## **Application by Longfield Solar Energy Farm Limited for an Order Granting Development Consent for the Longfield Solar Farm project.**

### **The Examining Authority's Written Questions and Requests for Information (ExQ1)**

**Issued on 26 July 2022**

CLIENT: Longfield Solar Energy Farm Ltd

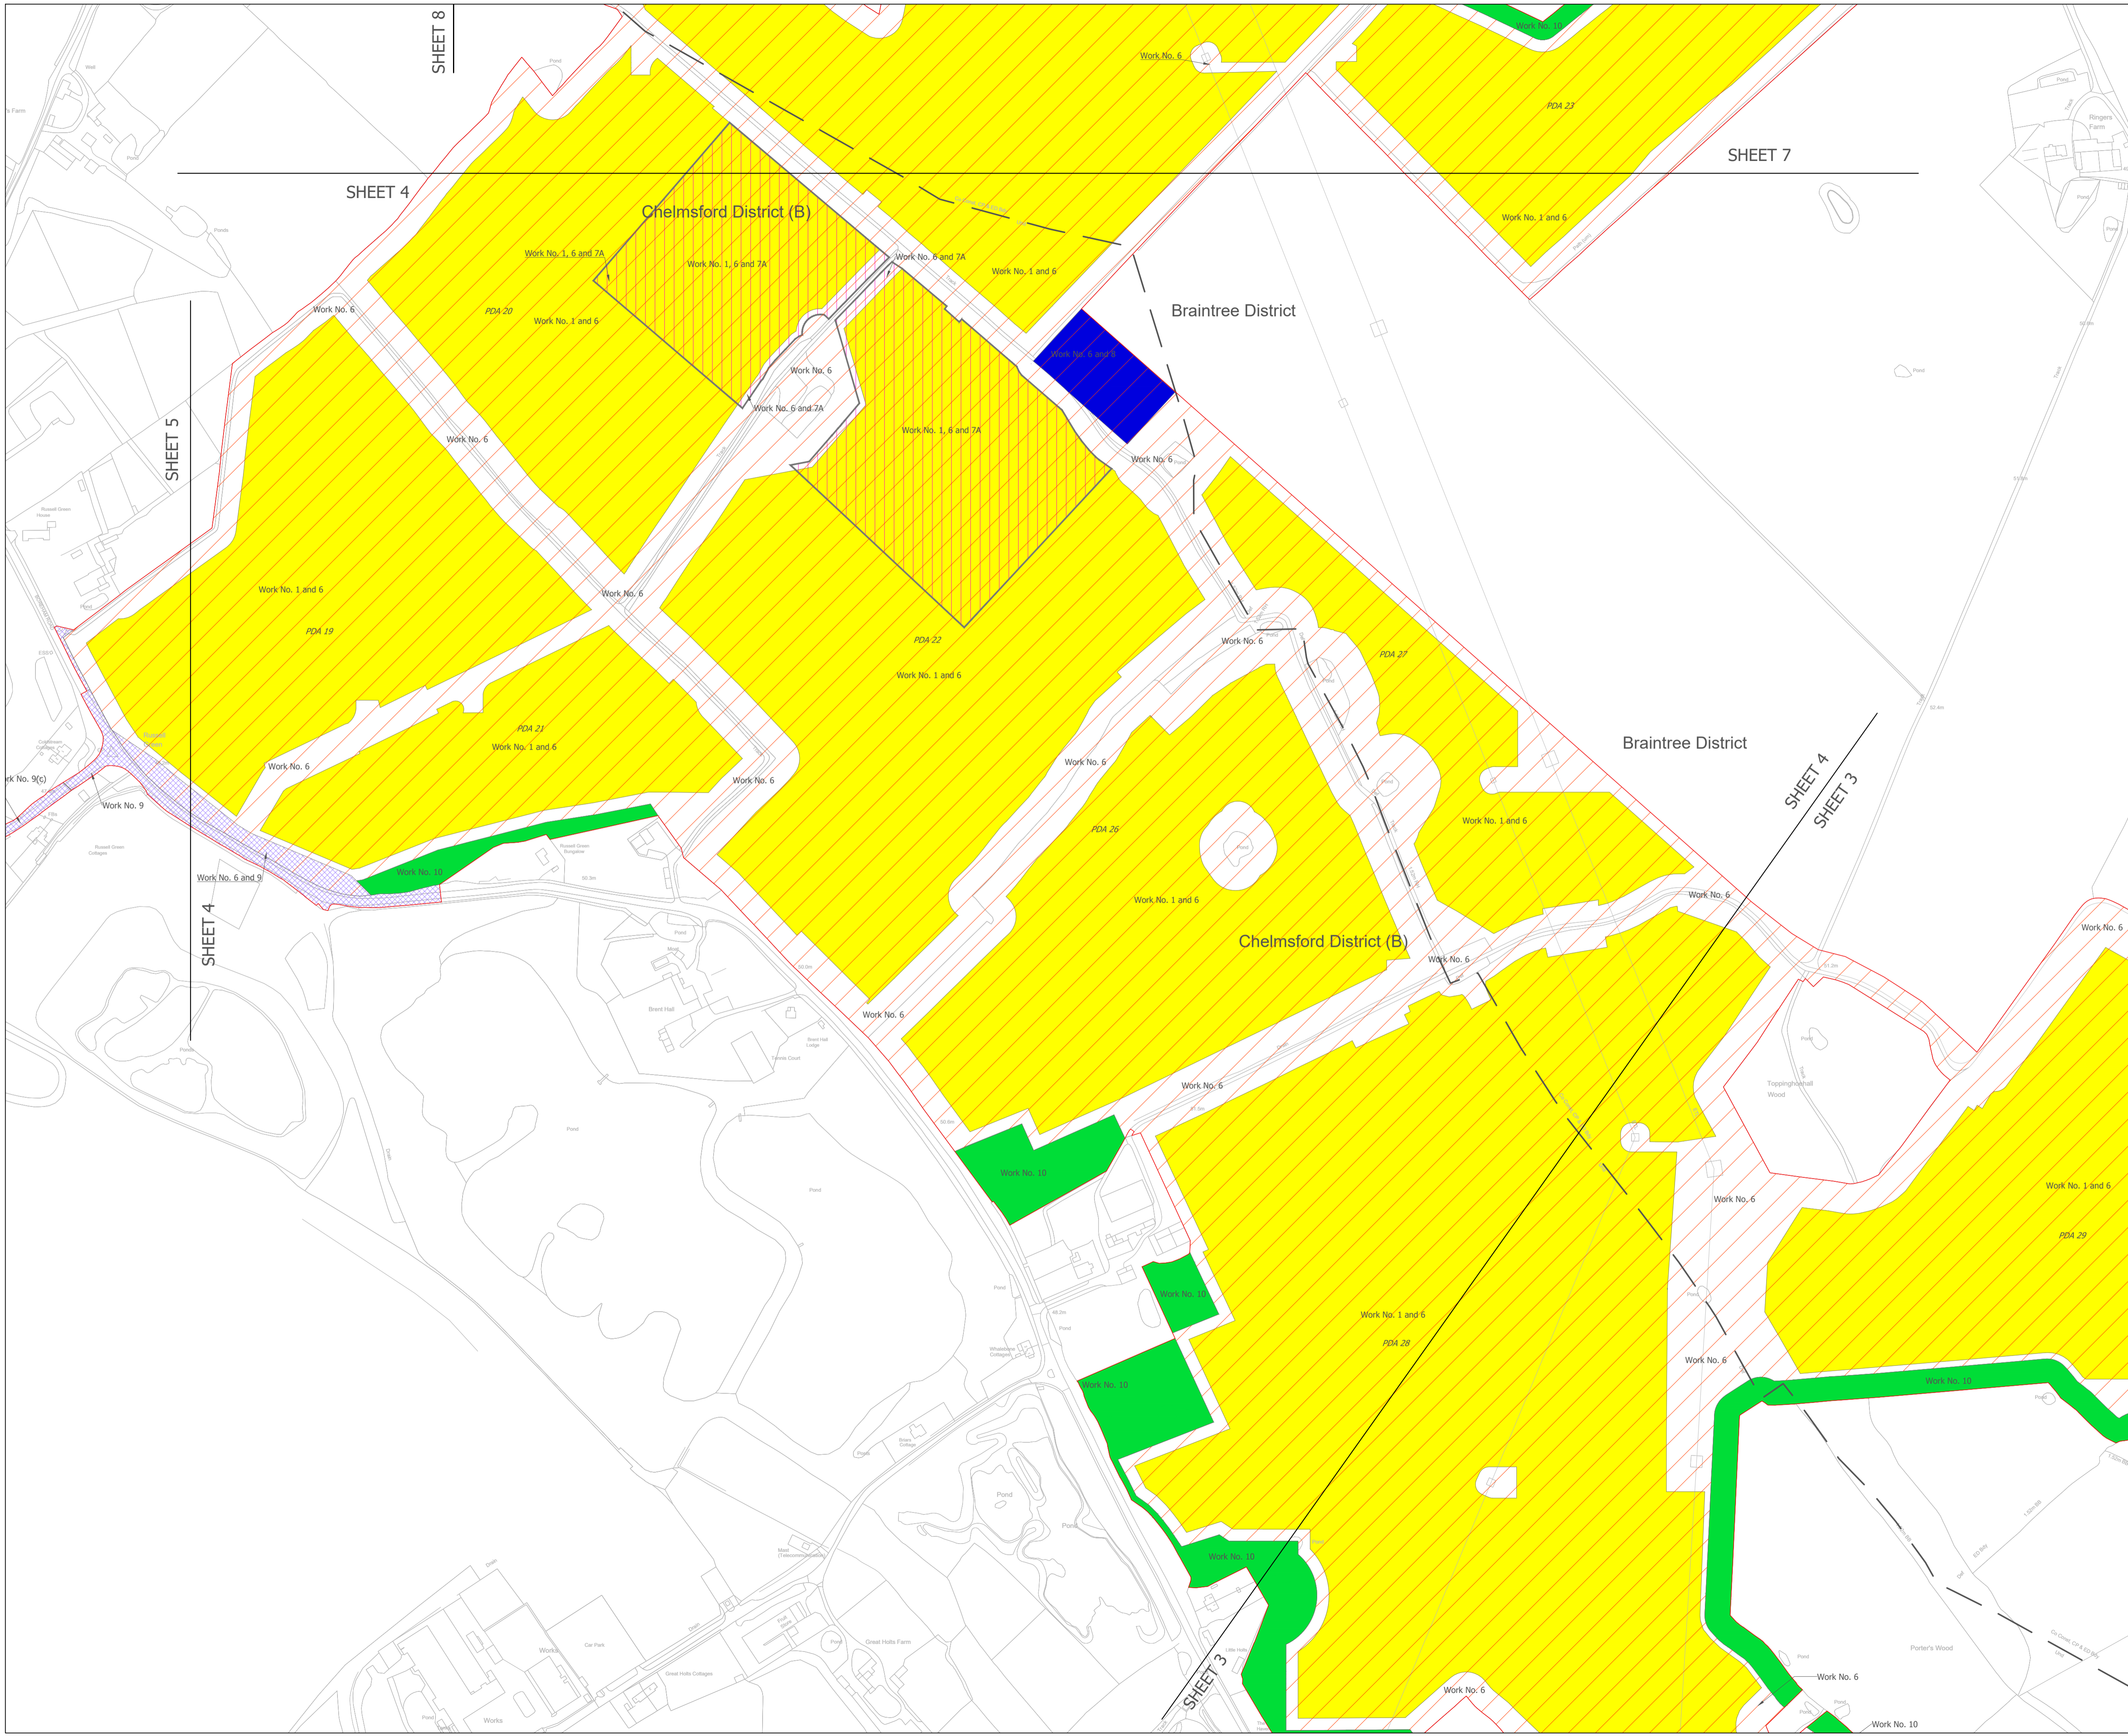
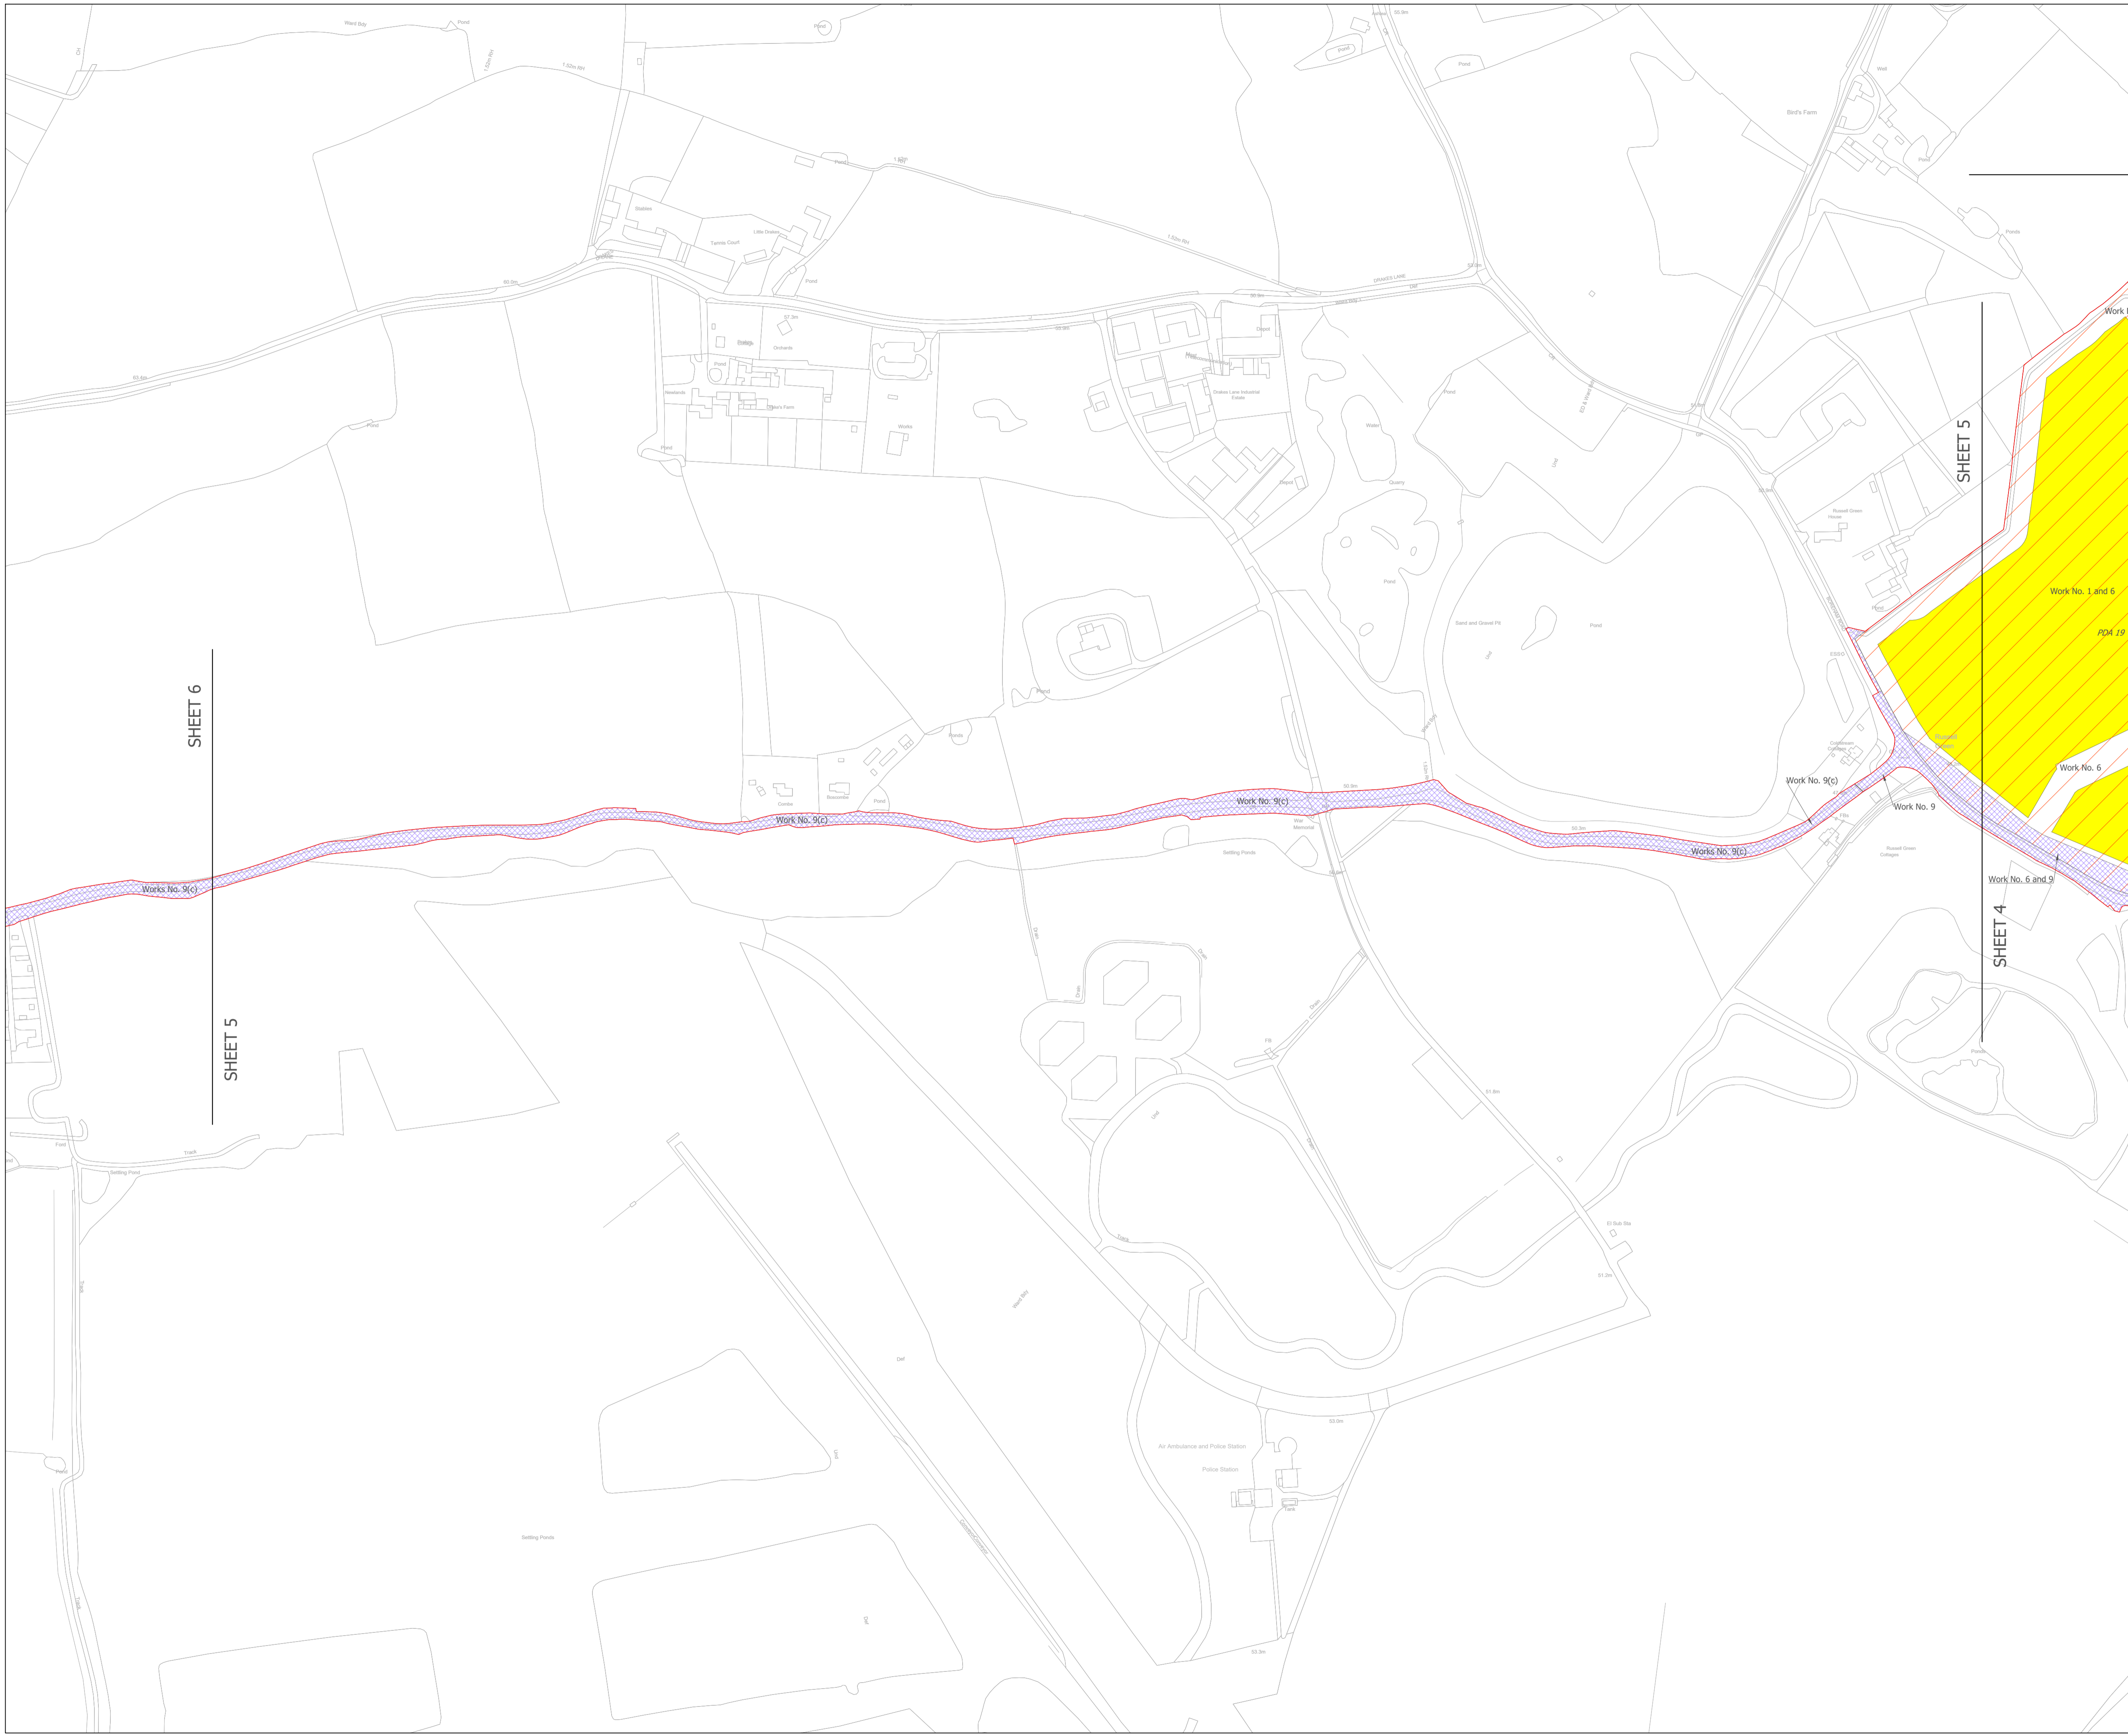
1.3.2	Applicant	The works plans show wide limits of deviation for a number of the works proposed. Please explain why this degree of flexibility is required and confirm that the limits of deviation have been reduced to the minimum extent necessary.
